From: [REDACTED]
Sent: 03 March 2019 11:28
To: Andrew Wood
Subject: planning application FG/220/18/PL New house in garden of Elm Lodge, Tamarisk Way, Ferring, BN12 5ER

Having carefully examined this application against the policies embedded in the Arun Local Plan, we believe that the application contravenes these policies in the following ways:-

Drawing Title PROPOSED GROUND AND
FIRST FLOOR PLANS

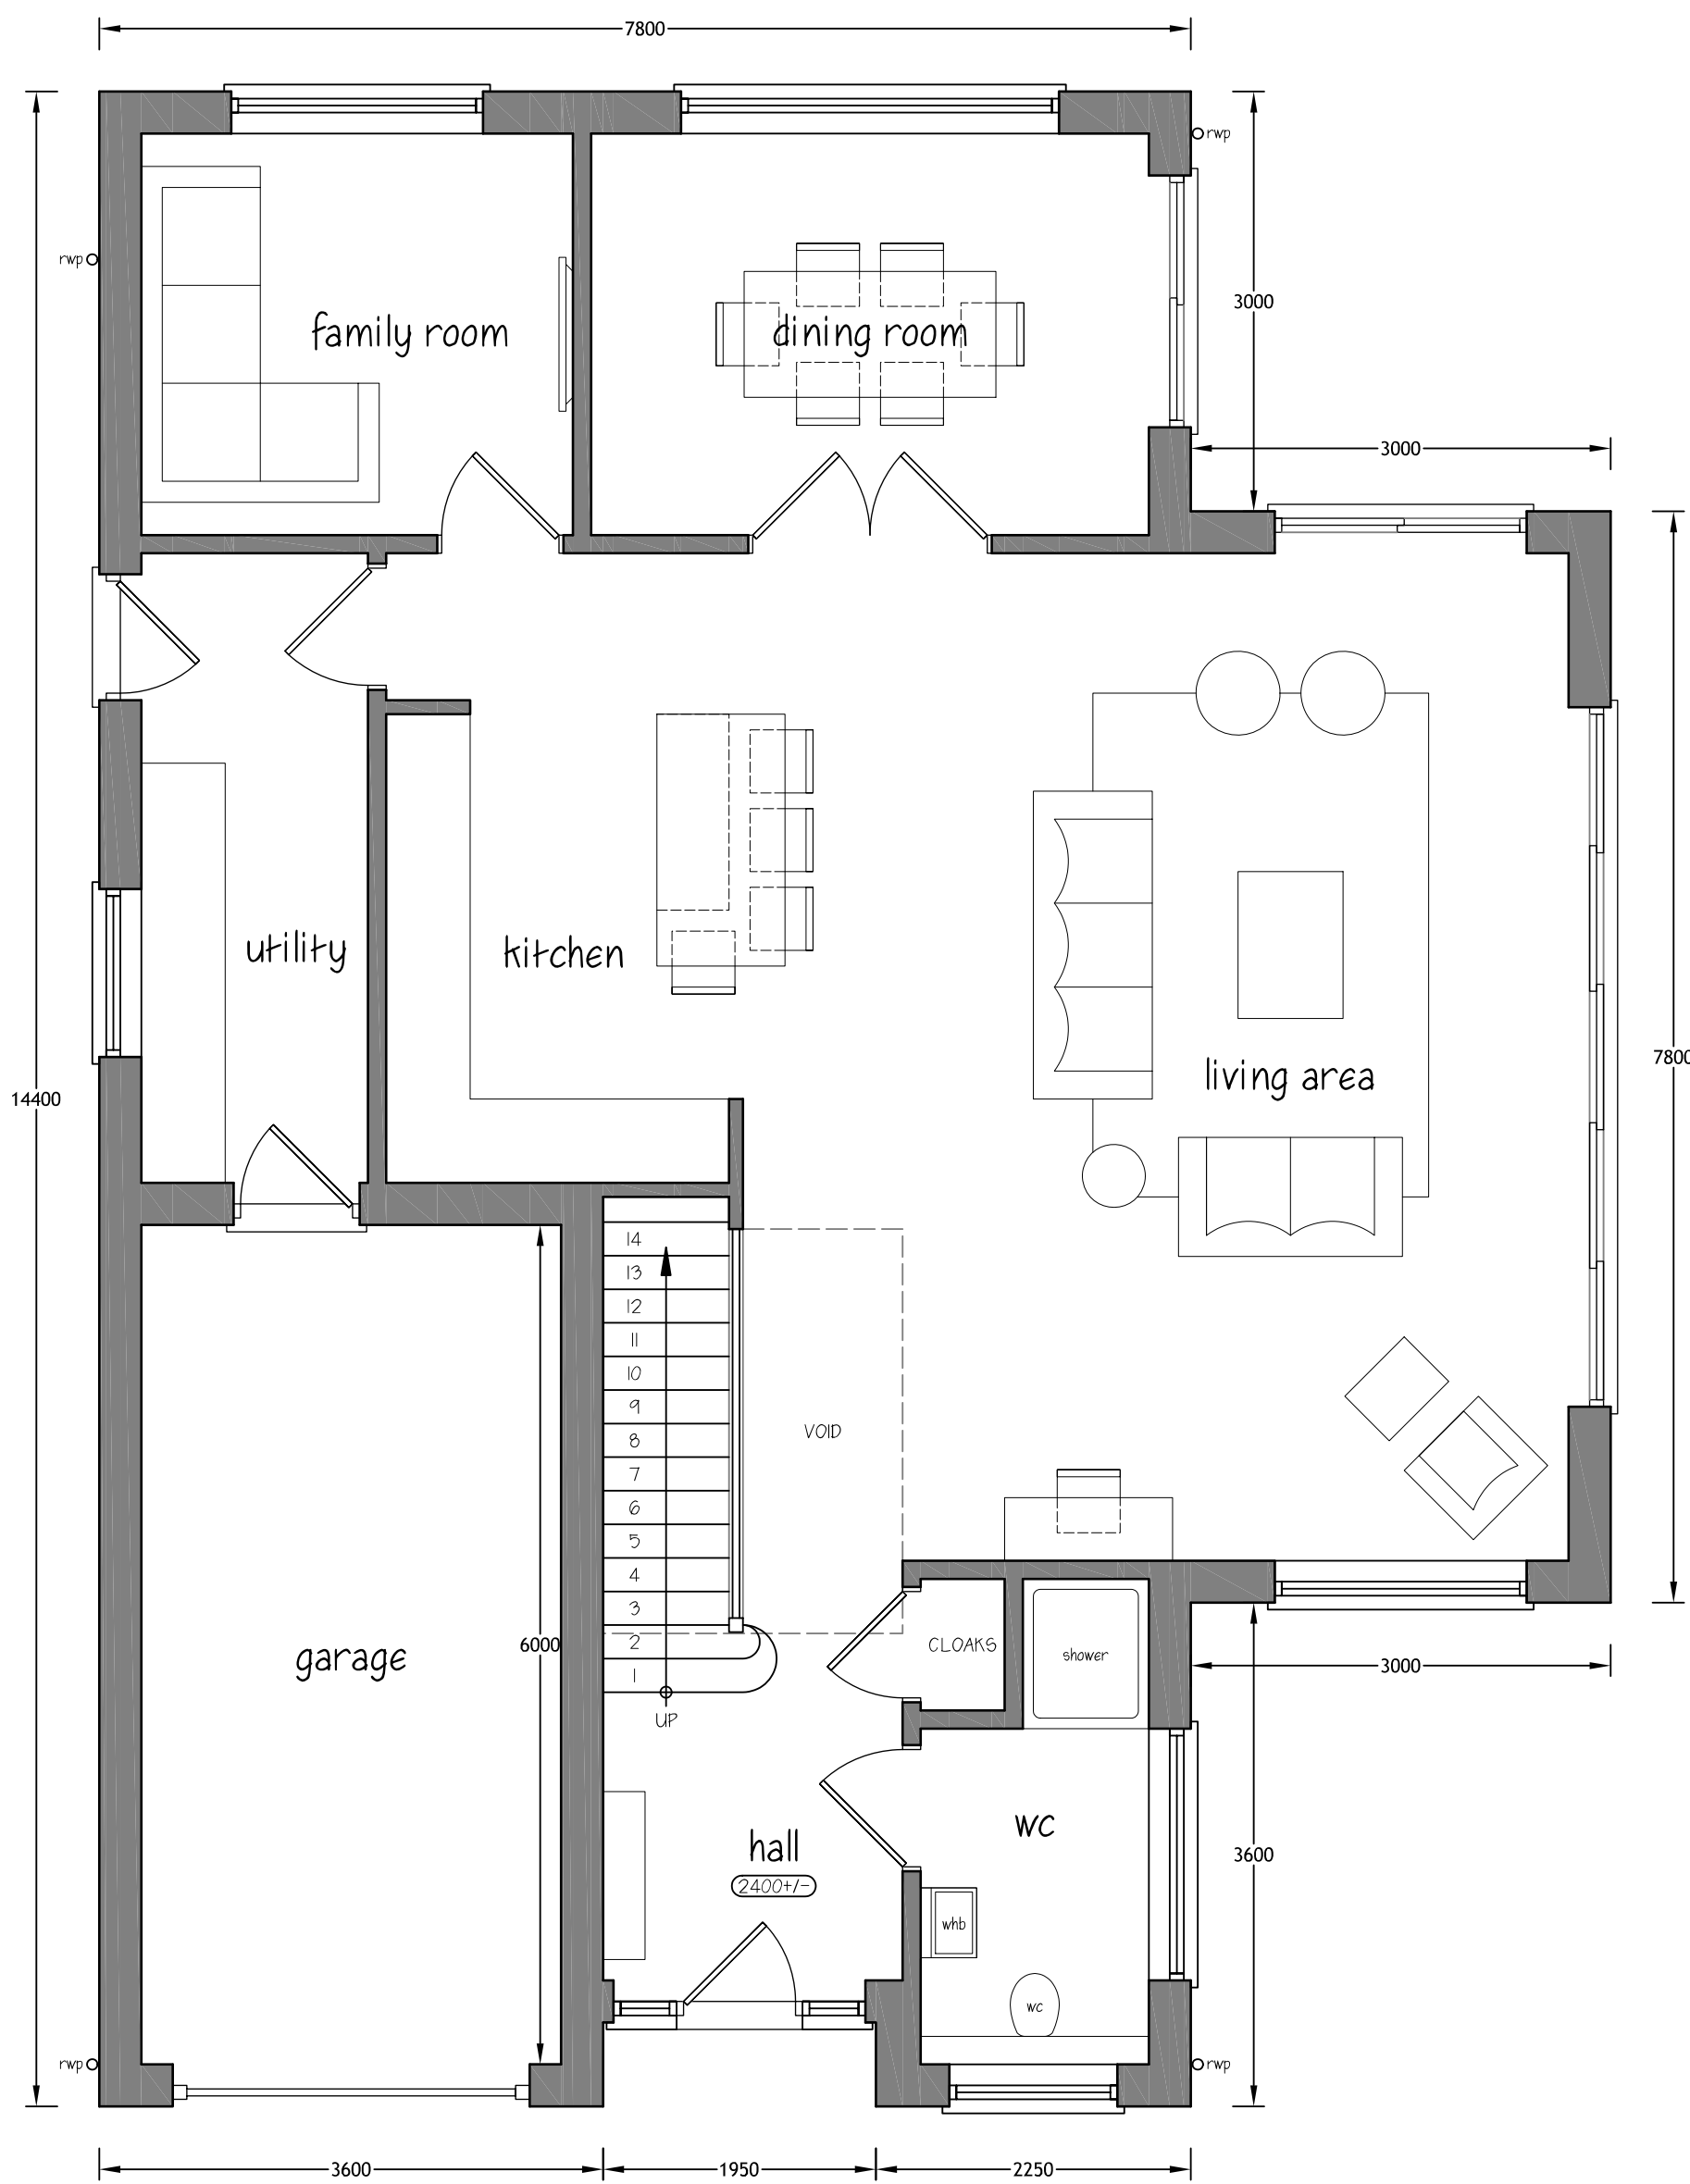
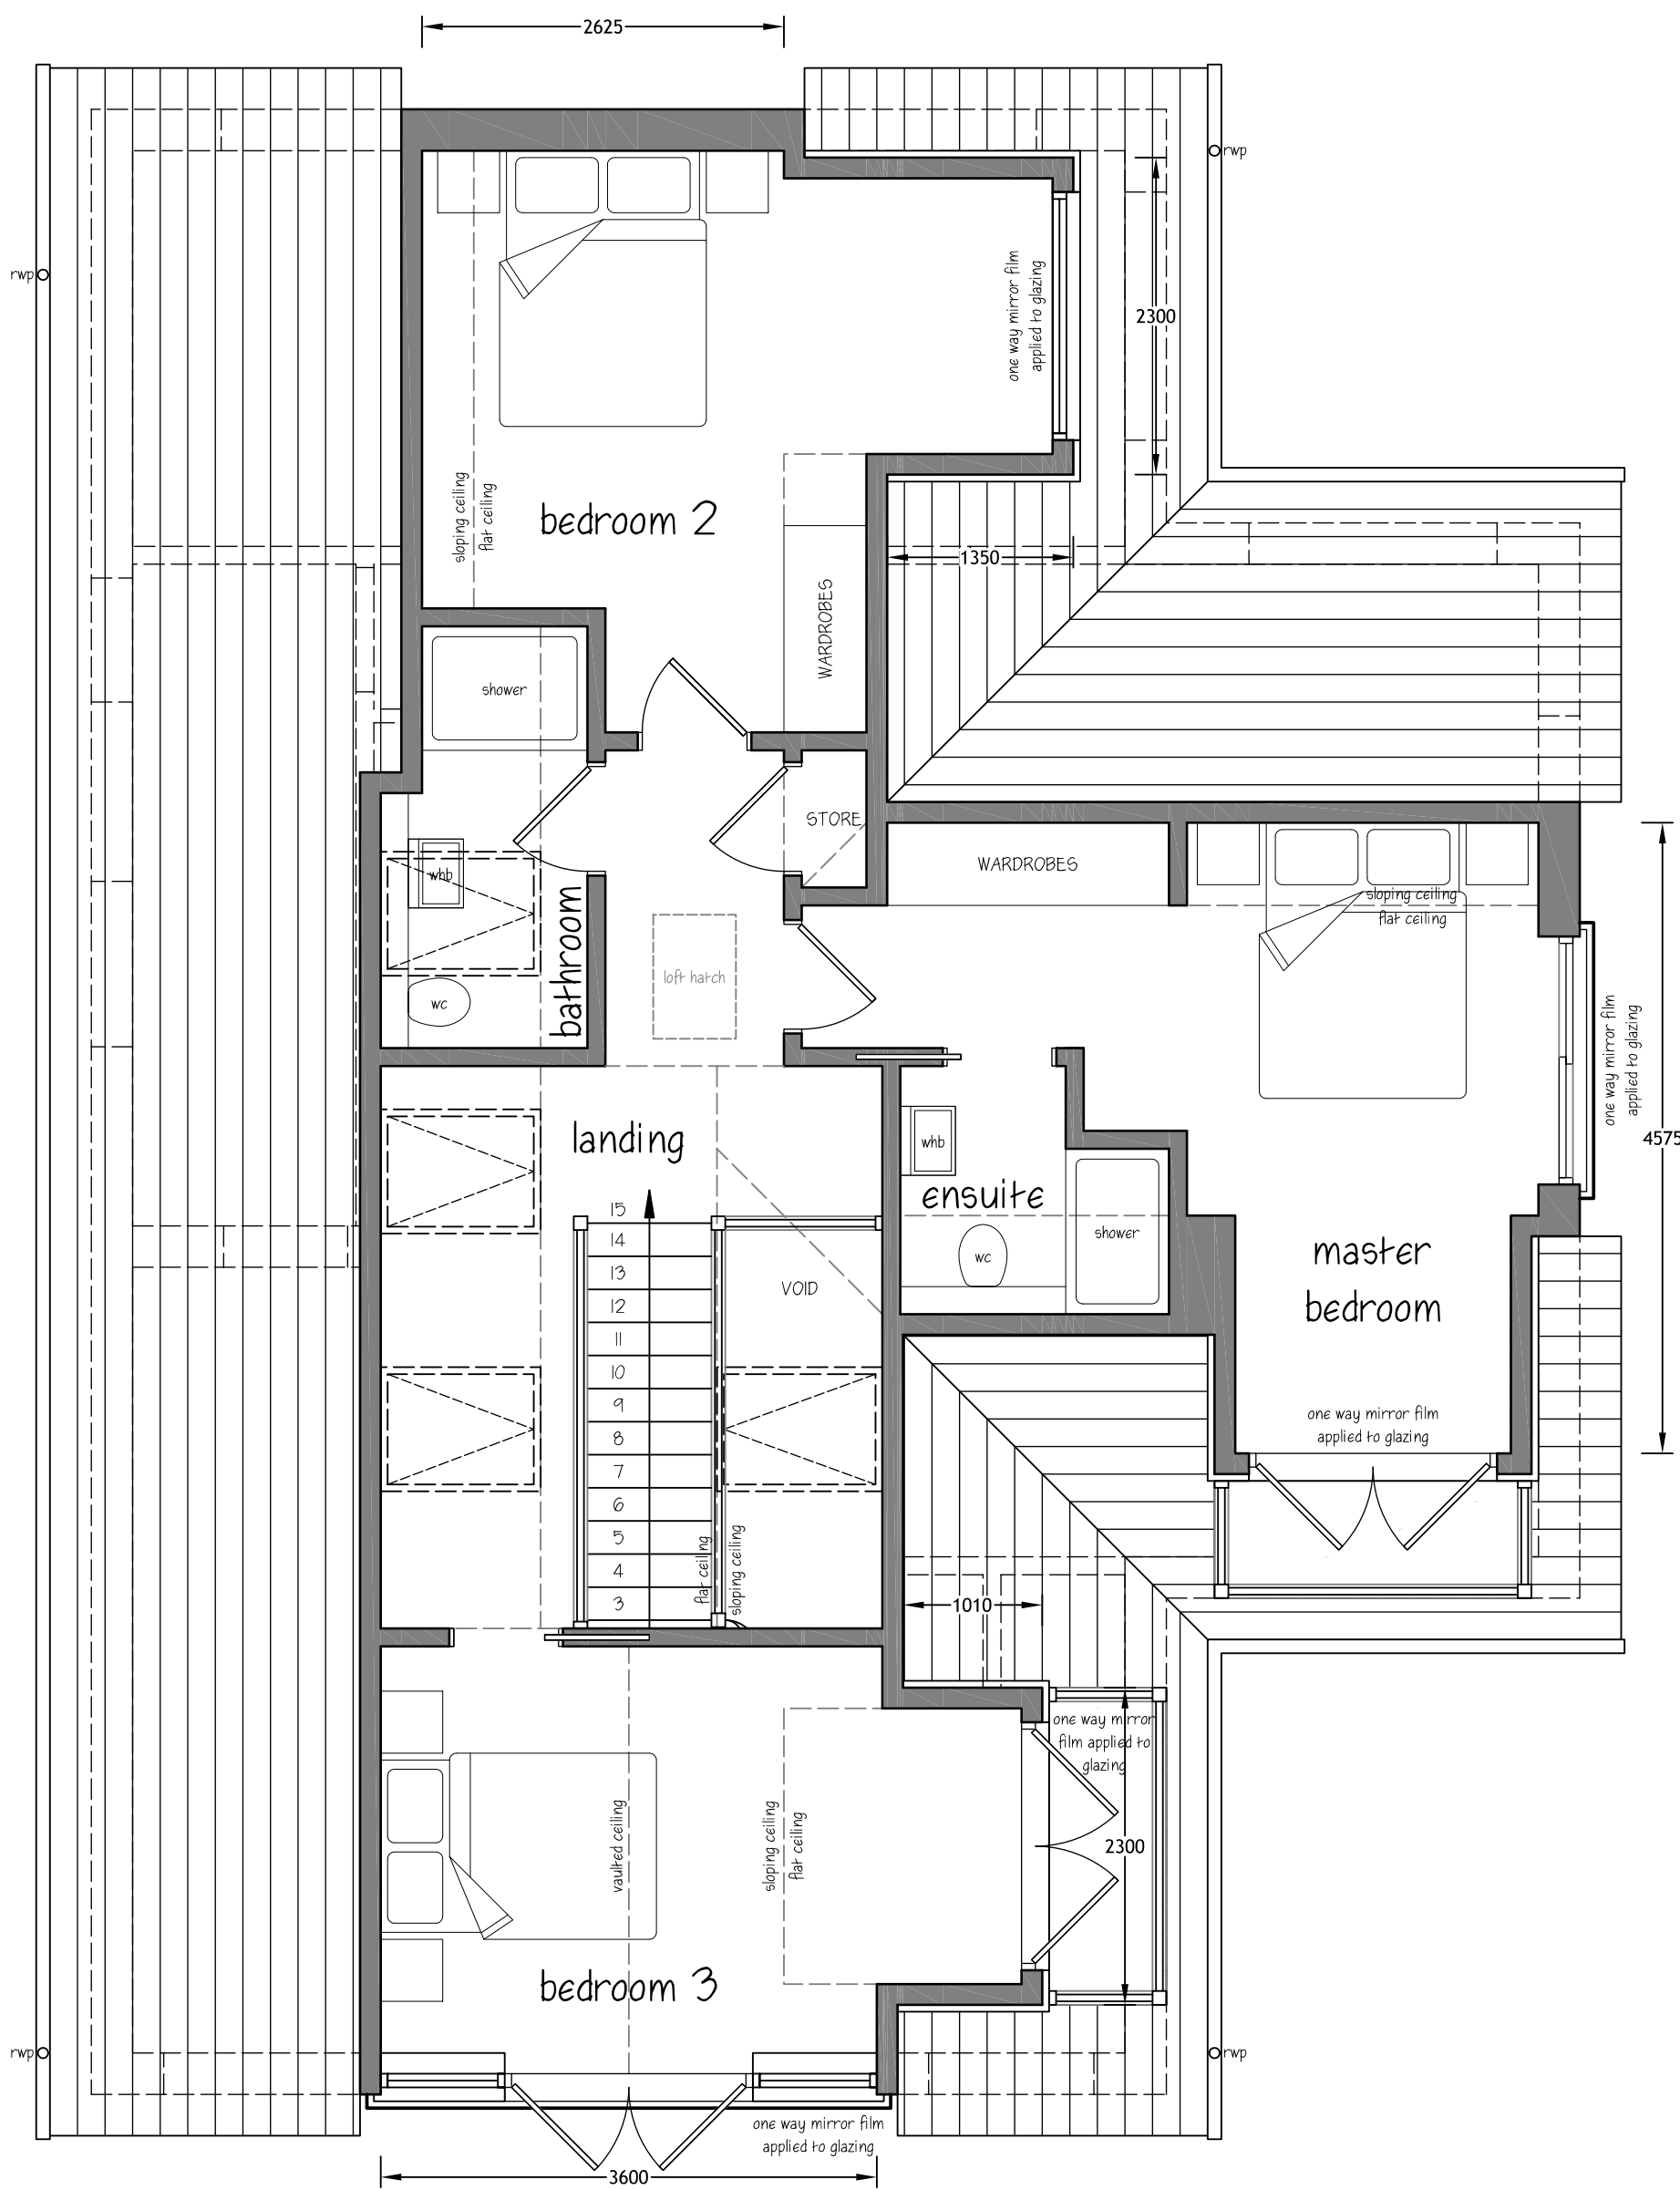
The proposed house plans call for 3 full length balcony windows on the first floor, 2 of which will look down directly into habitable areas and gardens of Magalia (one of these windows fully covers the entire 1st floor gable). We would point out that this is in addition to a third window which is to be installed in Elm Lodge and which is in fact less than the recommended distance from Magalia (see discussions held at a site visit from a member of the Arun Planning Dept. in November last year). This presents an excessive and unacceptable intrusion of privacy and we believe this to be contrary to the requirements of the Arun Local plan as detailed above
